From: Louise Crane
Sent: 13 February 2017 09:54
To: Planning.Responses
Subject: FW: Planning Consultation on: FG/198/16/PL

APPLICATION FG/198/16/PL

Site Address: 1 Sea Drive Ferring BN12 5HD

Description of Works: Demolition of existing house with erection of 2 storey building comprising of 8No. residential 2 bedroom flats & associated external works

TITLE: PROPOSED PLANS

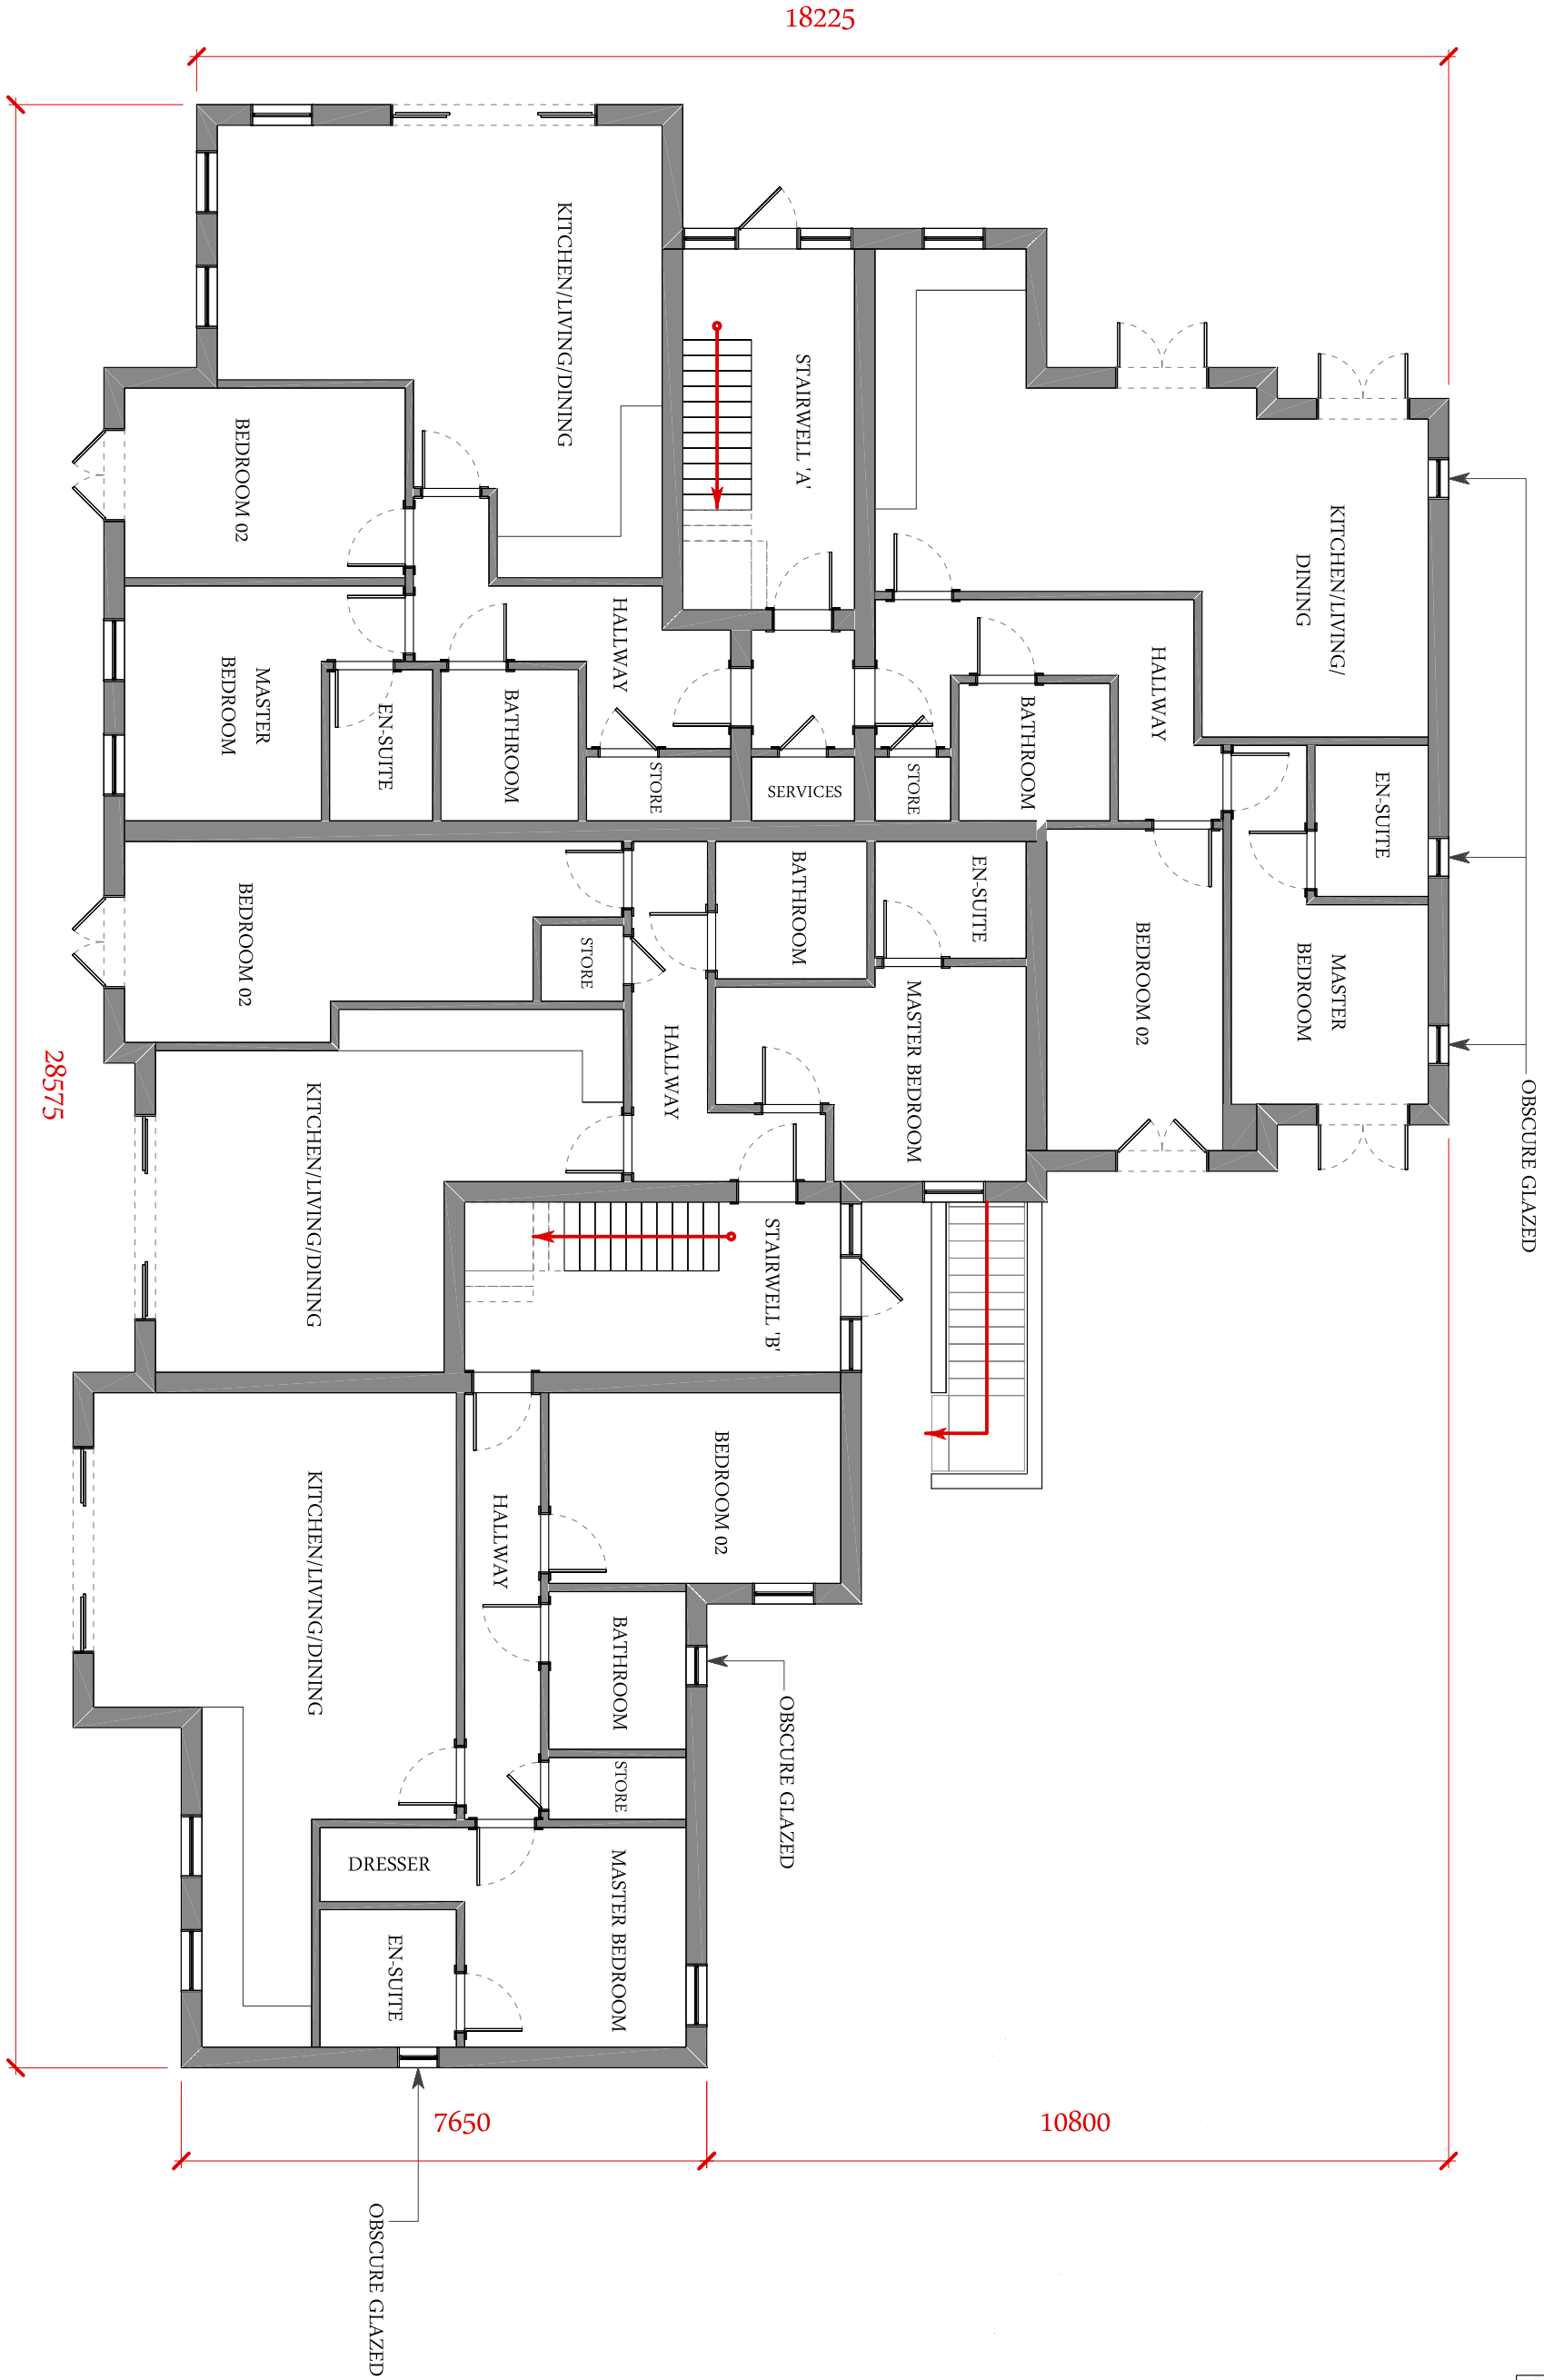
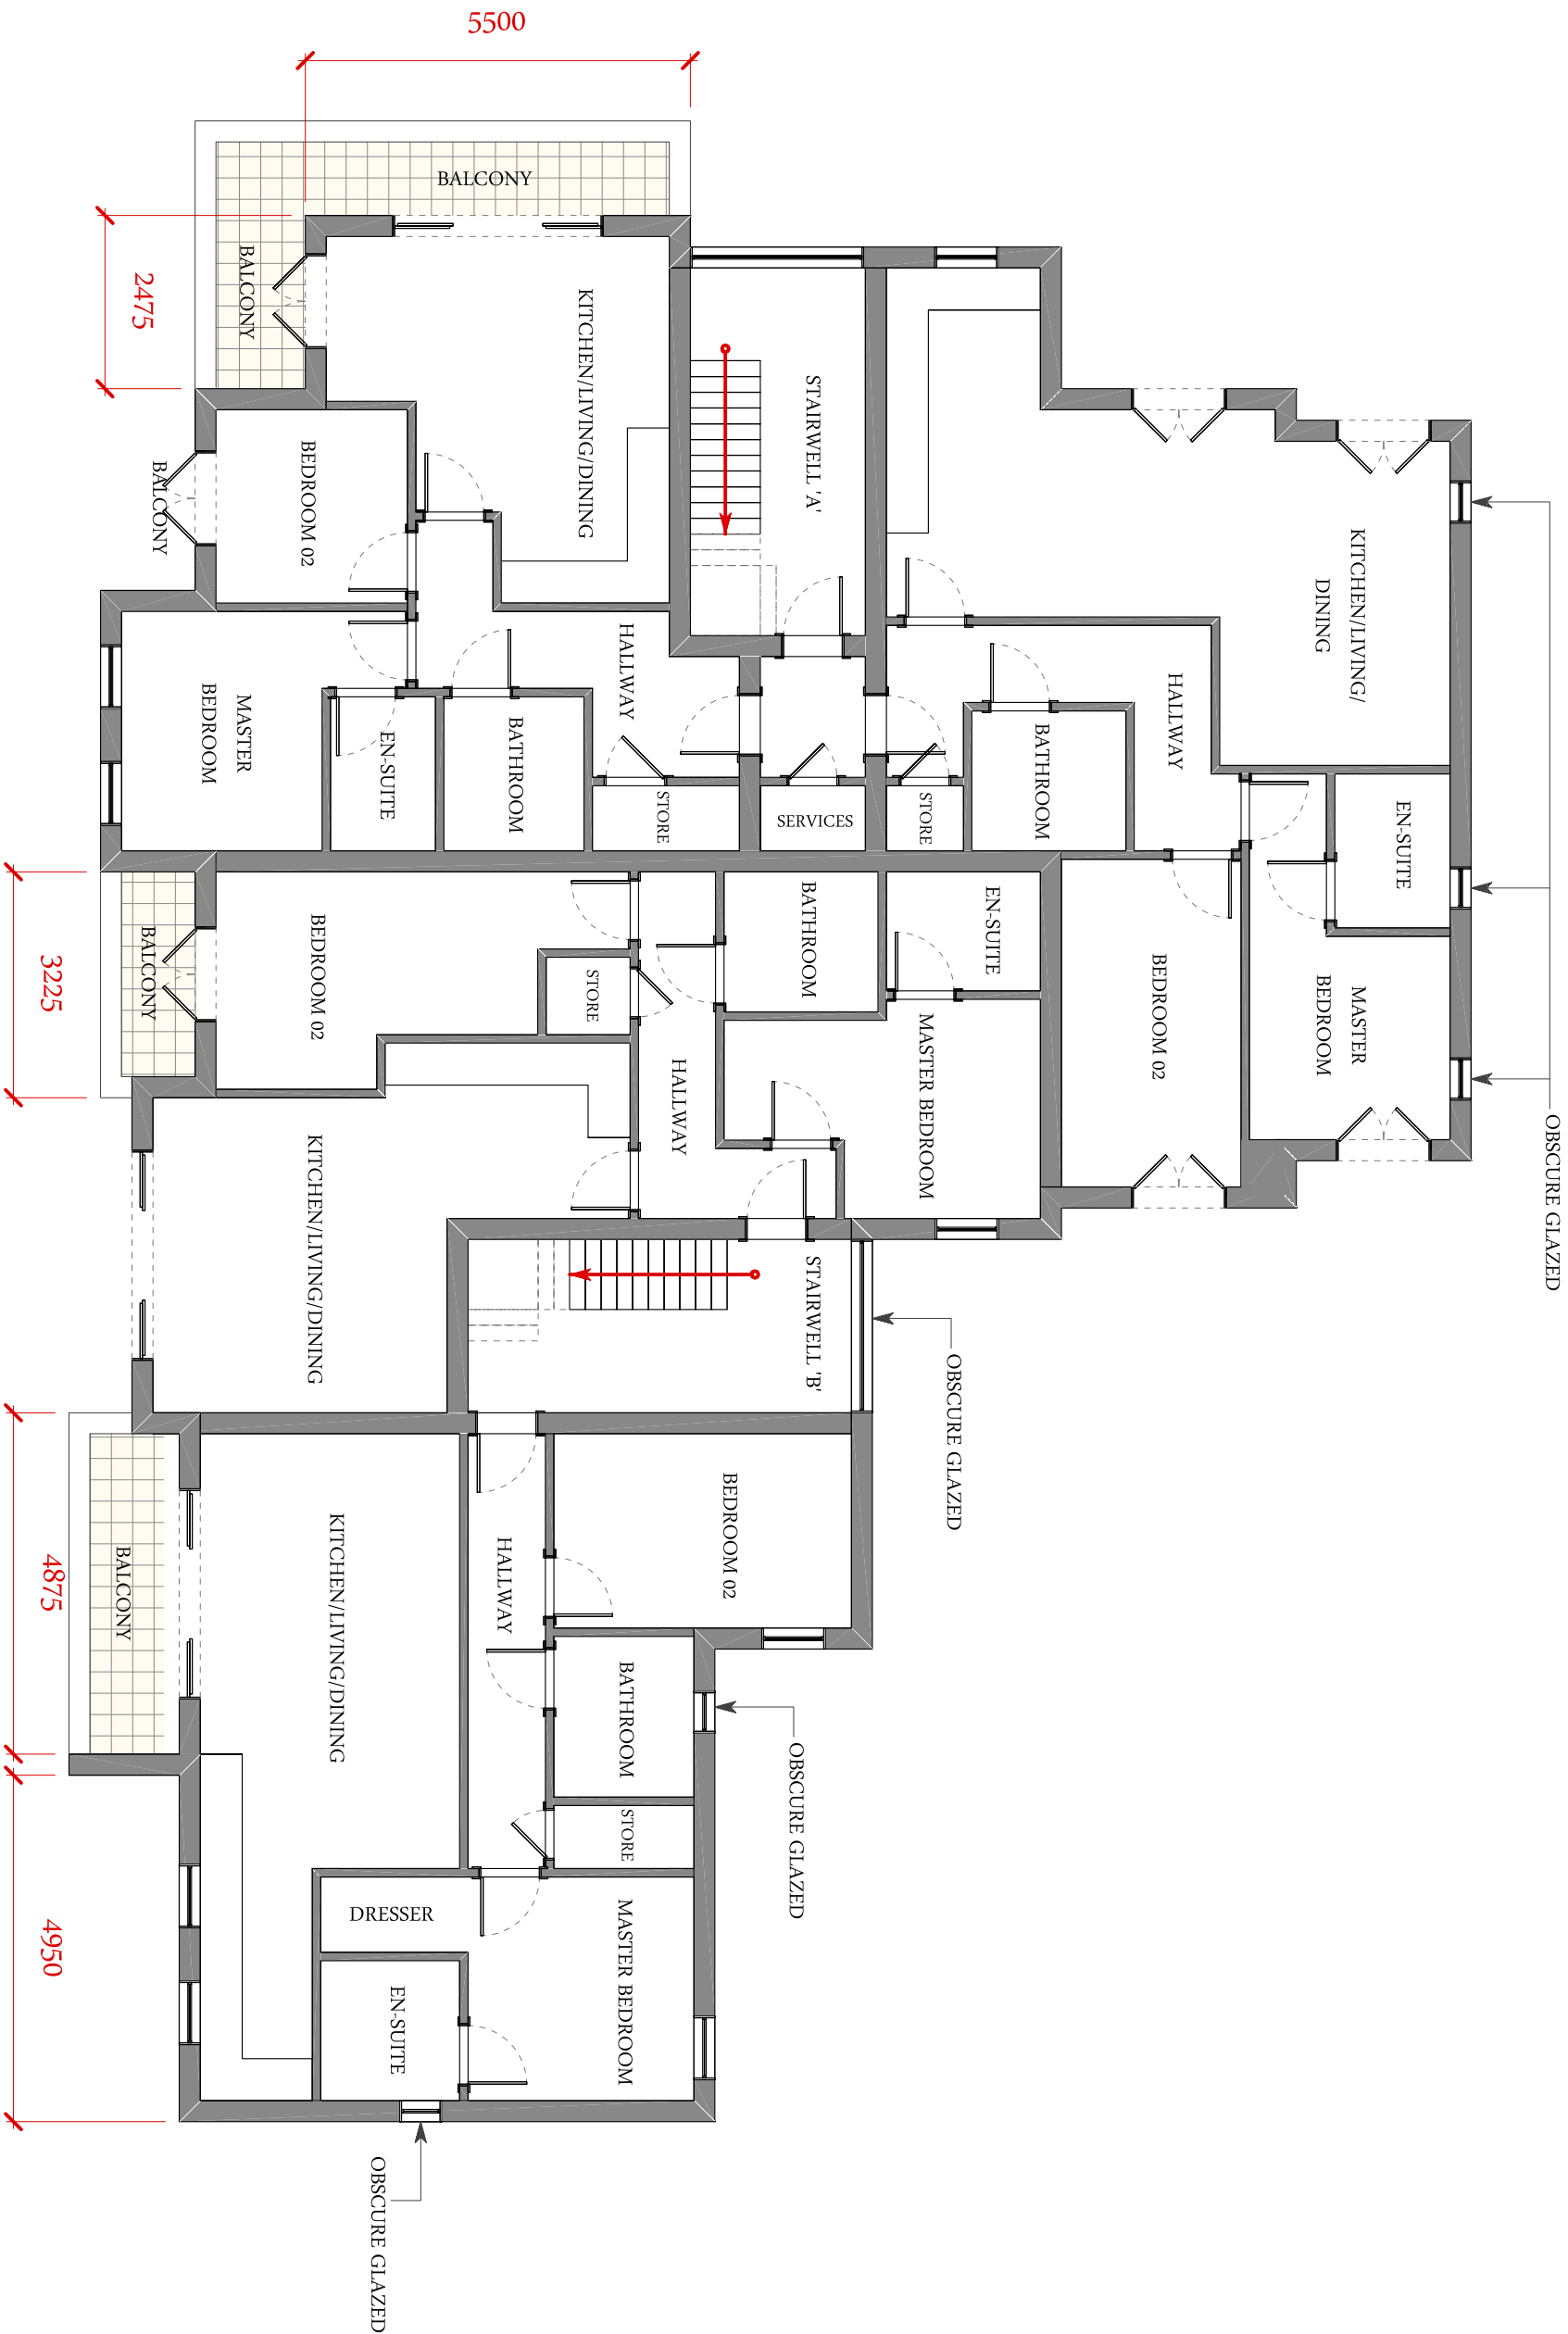
- Any bathrooms and kitchens without windows for natural ventilation should have adequate mechanical ventilation.

- Room sizes should meet the minimum standards for houses in multiple occupation if the flats are intended to be rented.

- The property would need to meet all fire detection and safety requirements as per the Lacors: Housing - Fire Safety: Guidance on fire safety provisions for certain types of existing housing, including adequate separation from any commercial units located below and external means of escape;
